# CITY OF ALBUQUERQUE

PLANNING DEPARTMENT – Development Review Services

May 25, 2016

**RE: Main Event, Albuquerque Carpenters Training Center (File: G16-D149)**  
**4040 Pan American Freeway NE 87107**  
**Grading Plan and Drainage Plan, Engineer's Stamp Date 5-14-2015**  
**Engineer's Certification Dated 5-19-16 sheet C5 only**

MAIN EVENT
PAN AM FREEWAY AND VASSAR AV.
INTERIM DRAINAGE PLAN - LOT 2B

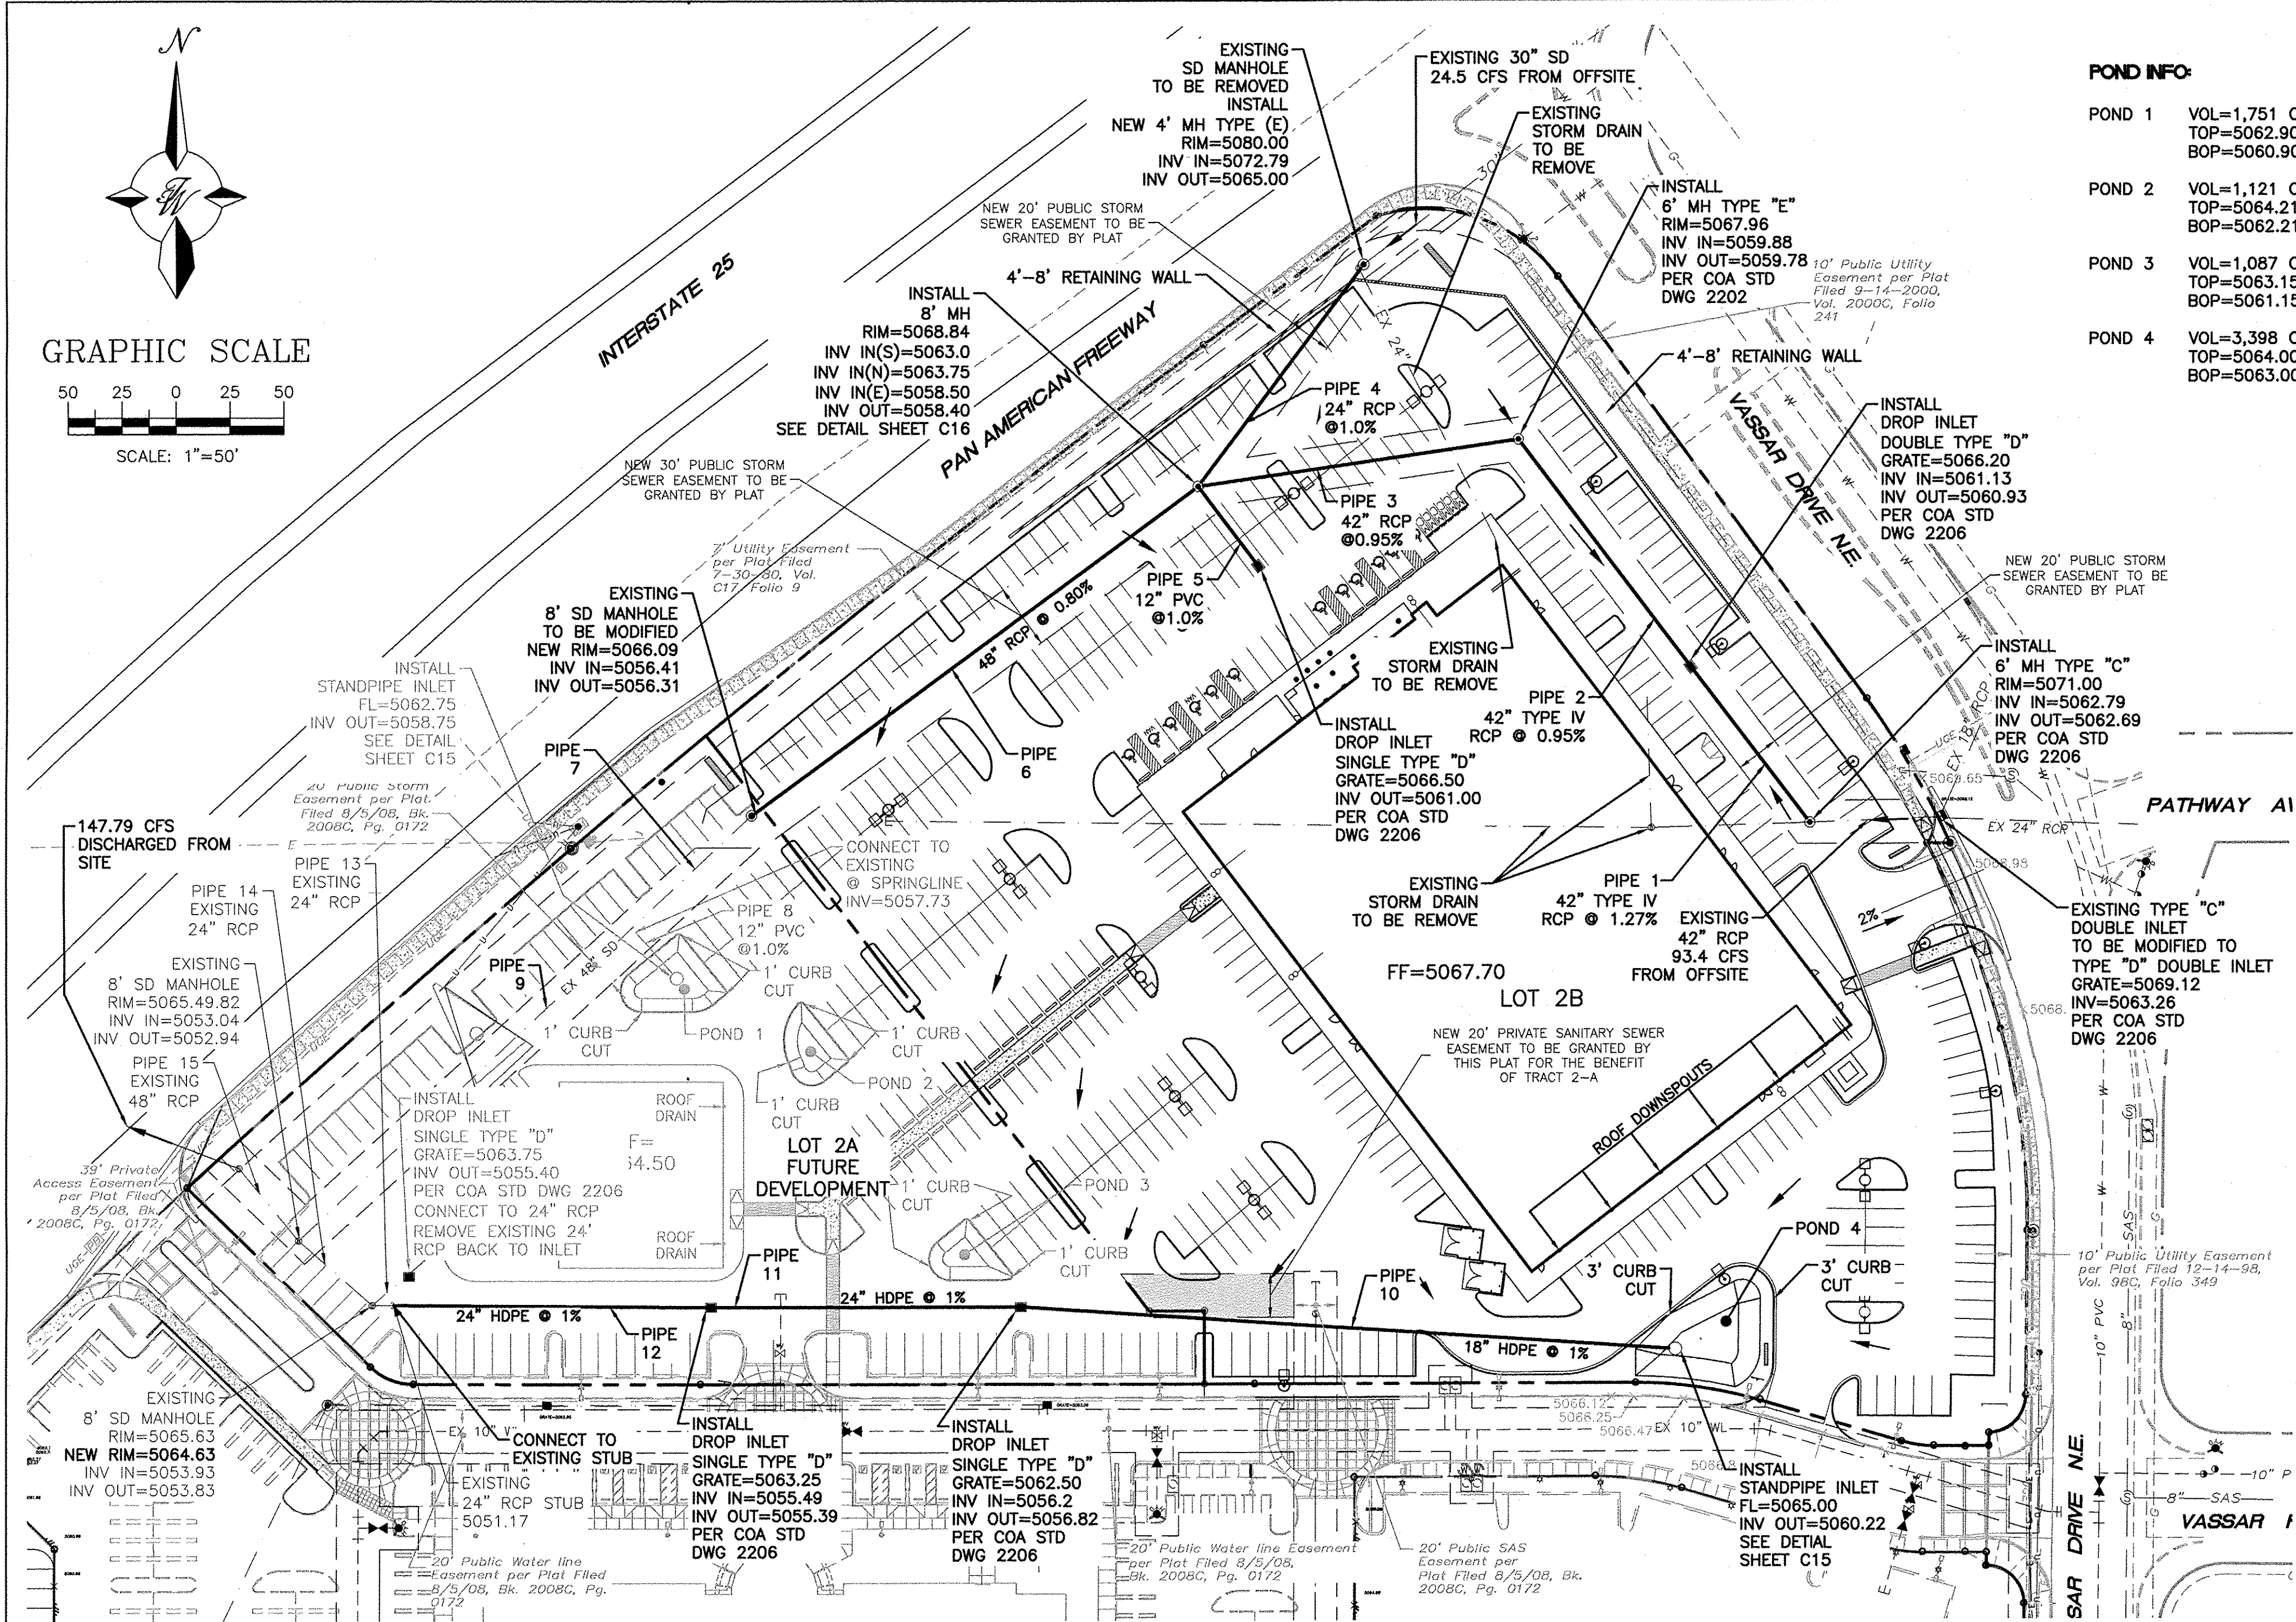
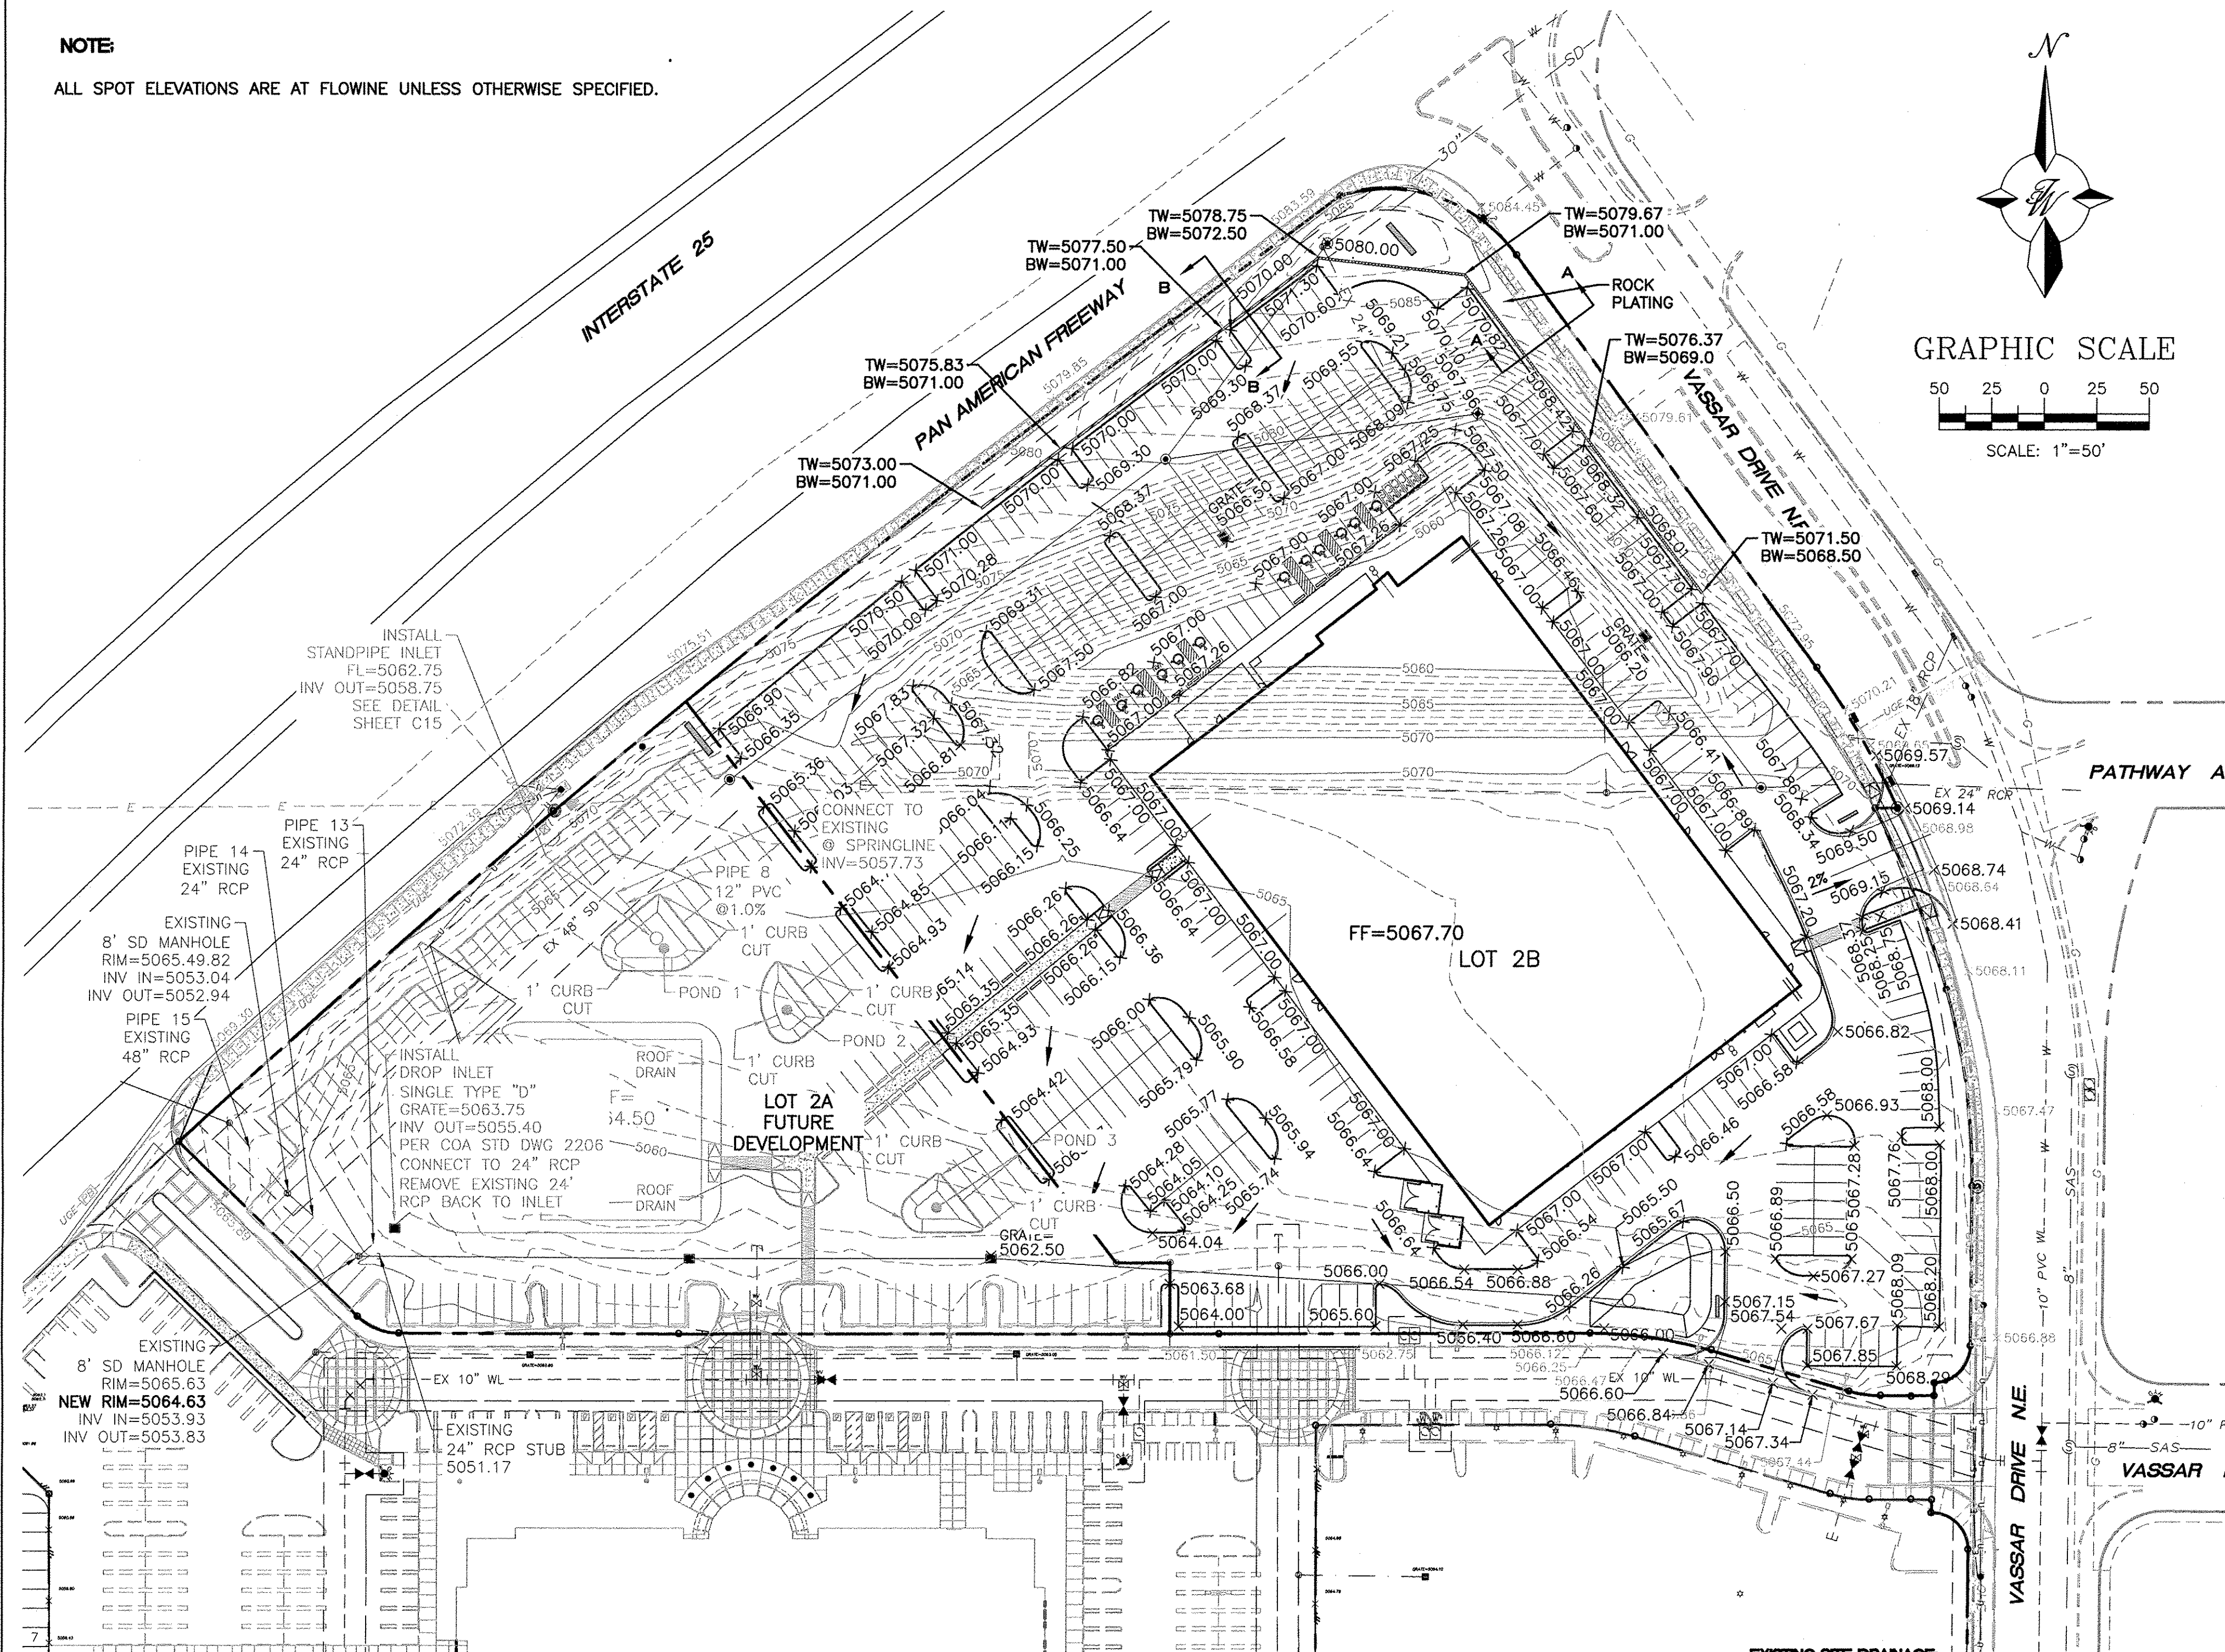
The grading plan that was approved showed two developed lots, with the northern lot draining to the southern lot. The southern lot has not been developed. Since the entire development was intended to be phased, there should have been an "interim" grading plan submitted and approved. The correct procedure is to have the engineer submit an interim grading plan for approval and then have that plan certified. In the future, provide an interim plan if the project is to be phased.
